June 4, 2020

Re: The Learning Experience (Academy of Early Education)
4580 Nunzio Ave. NW
Traffic Circulation Layout
Engineer's Stamp 06-02-20(C12-D003C)

Based upon the information provided in your submittal received 06-02-2020, the above referenced plan cannot be approved for Building Permit until the following comments are addressed:

THE LEARNING EXPERIENCE HORIZONTAL SIGHT DISTANCE EXHIBIT

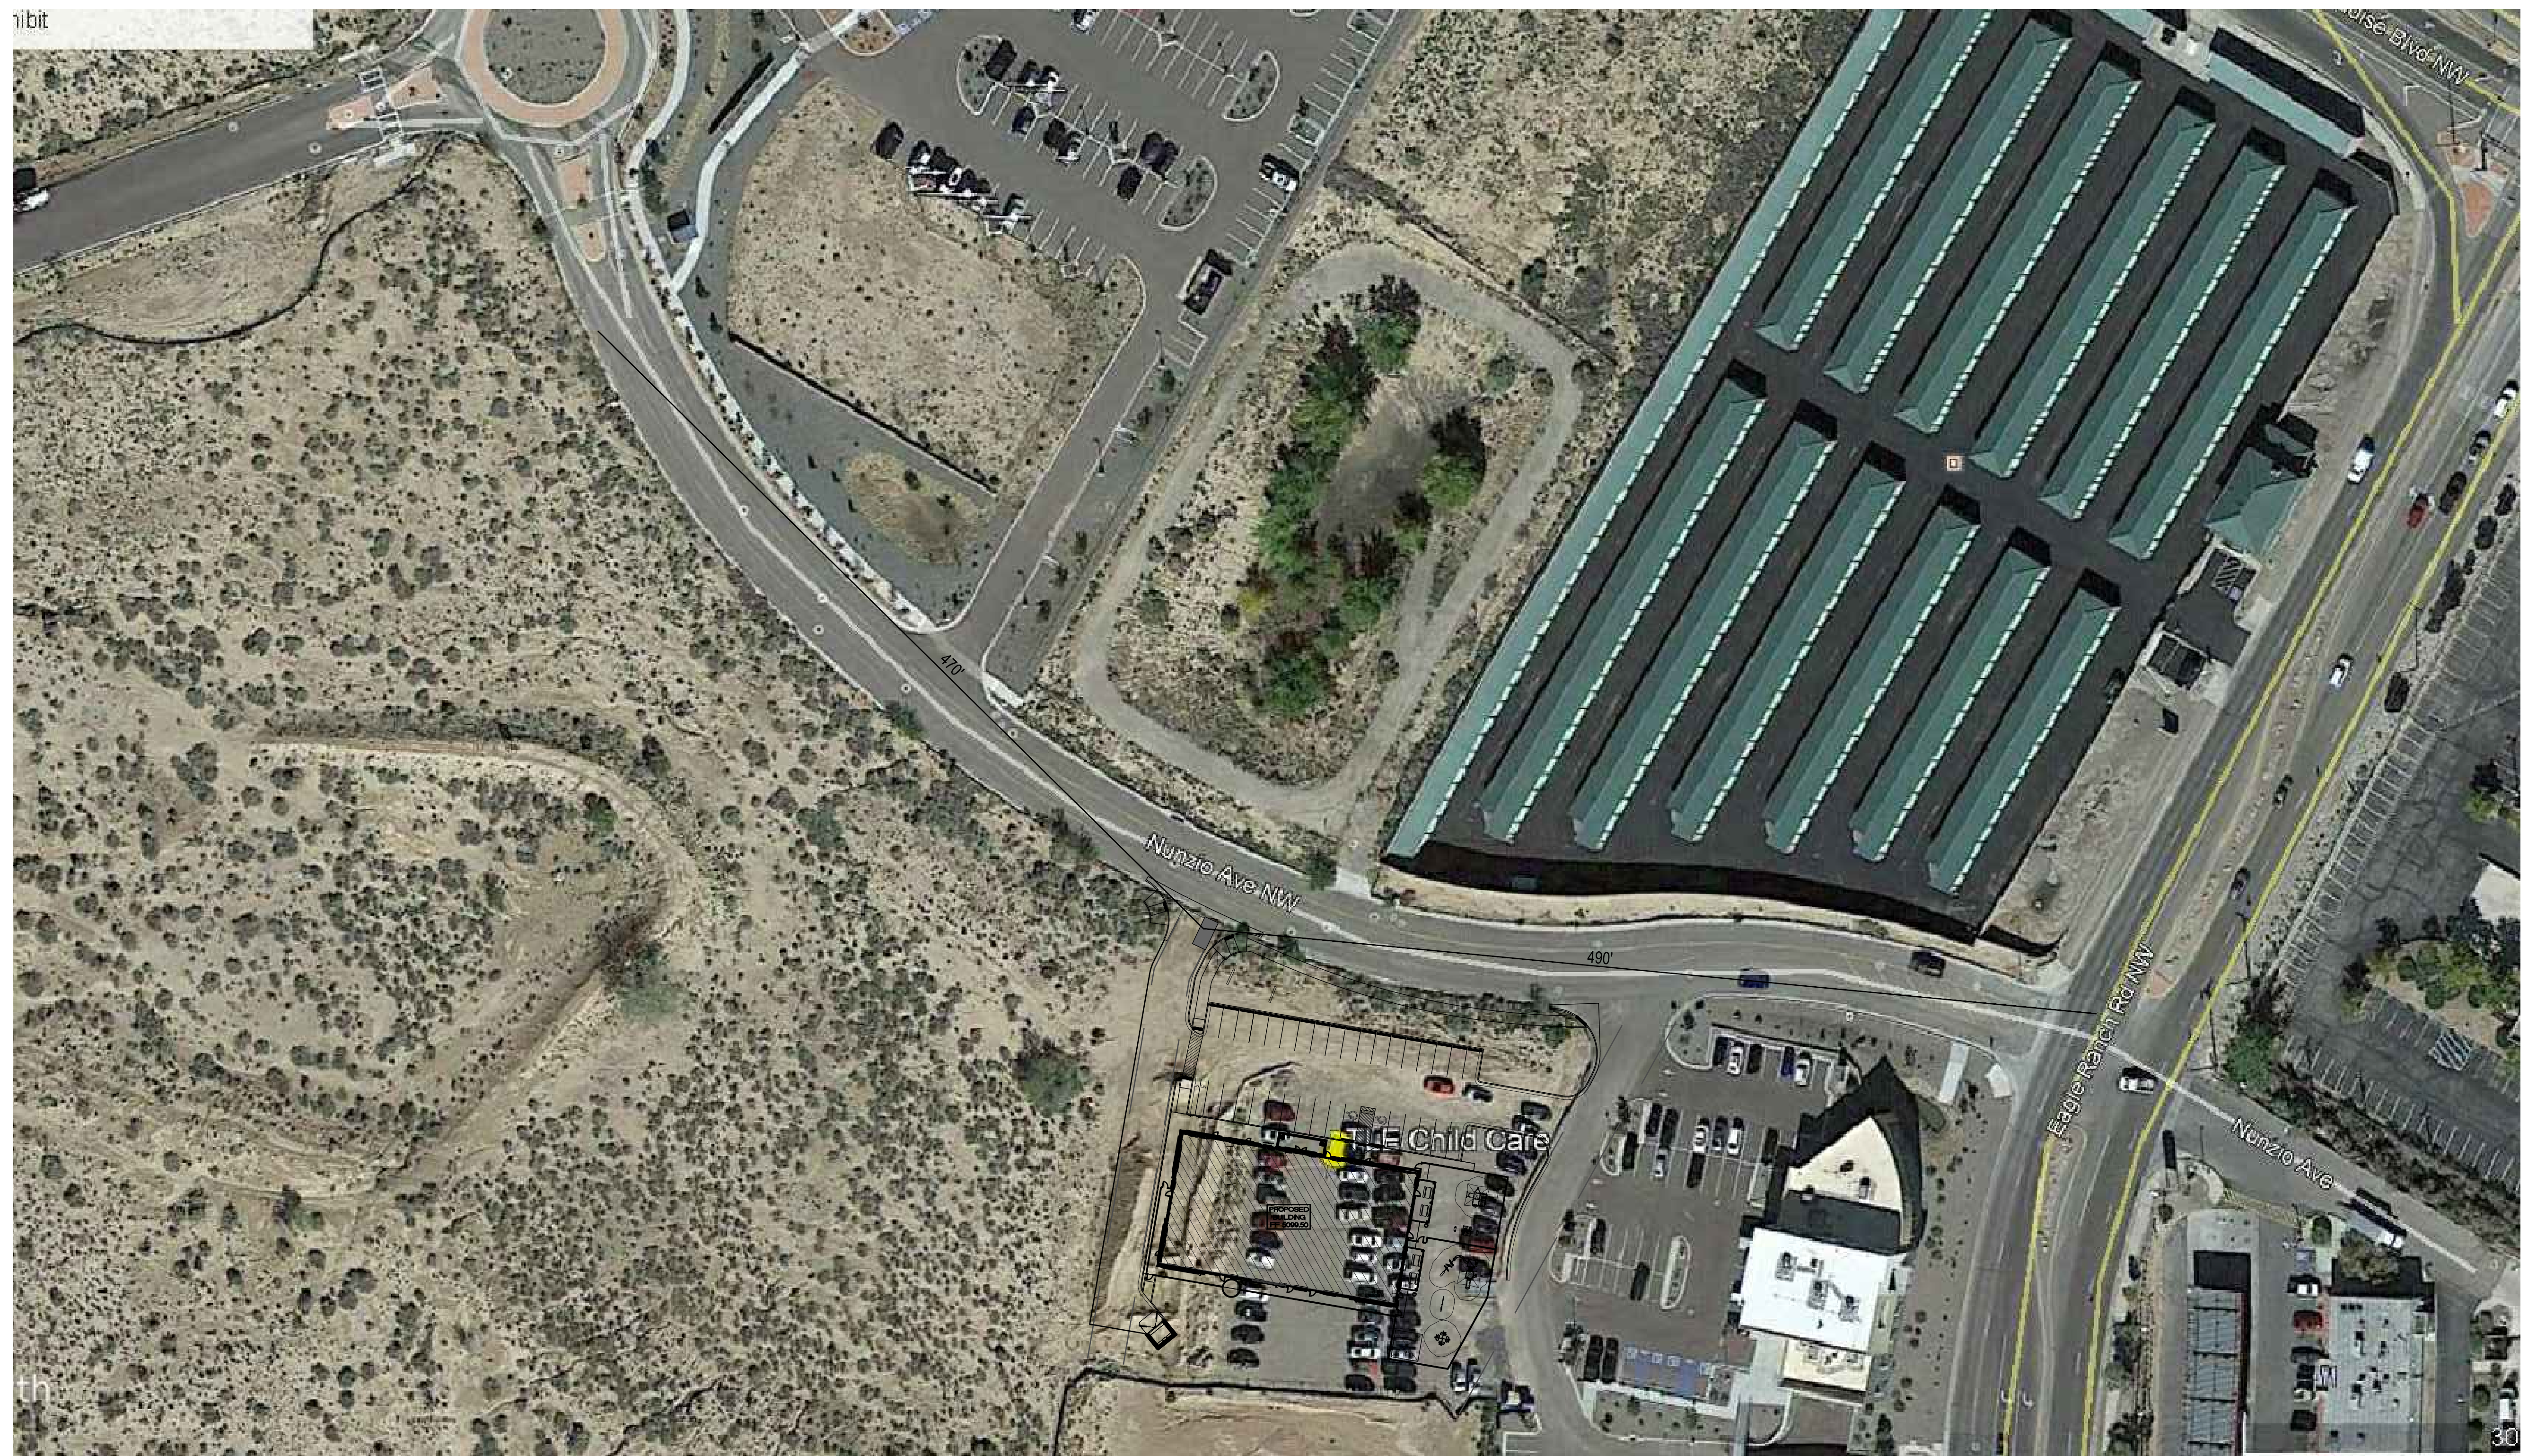
20. Please provide a sight distance exhibit
21. **Show the clear sight triangle and add the following note to the plan:**
"Landscaping and signage will not interfere with clear sight requirements. Therefore, signs, walls, trees, and shrubbery between 3 and 8 feet tall (as measured from the gutter pan) will not be acceptable in the clear sight triangle."

THE LEARNING EXPERIENCE
SITE PLAN - TRAFFIC CIRCULATION PLAN

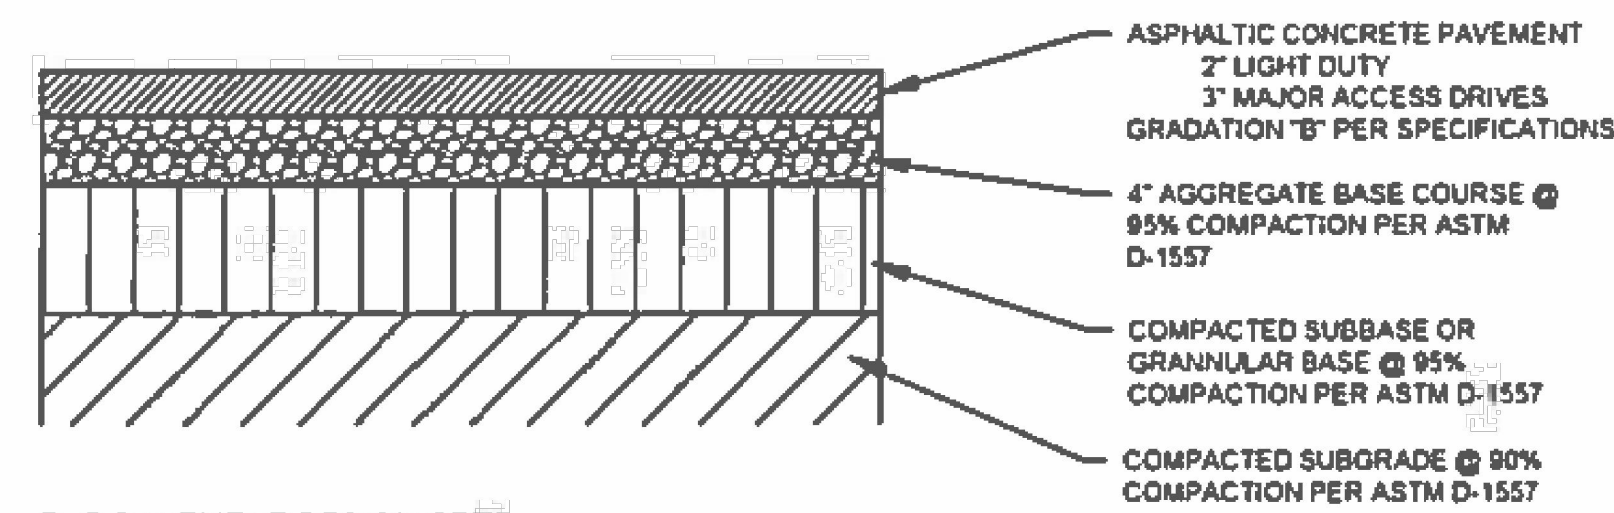
1. Please coordinate all calculations for parking spaces, including bicycle and motor cycle parking with Zoning and list the number required.
2. Identify all existing access easements and rights of way width dimensions.
3. Identify the right of way width, medians, curb cuts, and street widths on Nunzio
4. The minimum parking stall dimensions are:

5. The ADA accessible parking sign must have the required language per 66-7-352.4C NMSA 1978 **"Violators Are Subject to a Fine and/or Towing."** Please call out detail and location of signs.
6. The ADA access aisles shall have the words **"NO PARKING"** in capital letters, each of which shall be at least one foot high and at least two inches wide, placed at the rear of the parking space so as to be close to where an adjacent vehicle's rear tire would be placed. (66-1-4.1.B NMSA 1978)
7. ADA curb ramps must have truncated domes installed.
8. The proposed 6ft valley gutter will need to be completely constructed across the existing 25 ft private access coming off Nunzio.

9. The proposed 20 ft private access easement will need to be approved prior to TCL(traffic circulation layout) plan approval. Both ADA ramps transition (wings) will need to be located on public sidewalk. Expect the ramp that is serving the proposed development, one transition can be on private property but the landing and other transition(wings) needs to be within public sidewalk.

14. Radius for delivery trucks, fire trucks, etc. is 25 ft. or larger (onsite).
15. Per the IDO, a 6 ft. wide ADA accessible pedestrian pathway is required from the public sidewalk **to the building entrances**. Please clearly show this pathway and provide details (proposed striping across access entrance off 20 ft proposed private access.

16. Per DPM, a 6 ft. wide ADA accessible pedestrian pathway is required from the ADA parking stall access aisles (**ramp width must be 6 ft wide**) to the building entrances. Please clearly show this pathway and provide details.

17. Parking areas shall have barriers to prevent vehicles from extending over sidewalk at building entrance and in front of proposed retaining wall and landscaping.

18. Do you need some type of signage or barricades to alert vehicle traffic of asphalt pavement termination on 20 ft proposed private access easement?
19. Provide a copy of refuse approval for proposed design and location of Refuse Enclosure.

22. Shared Site access: driveways that straddle property lines, or are entirely on one property but are to be used by another property, shall have an access easement. Please include a copy of your shared access agreement with the adjacent property owner on the proposed western entrance off Nunzio.
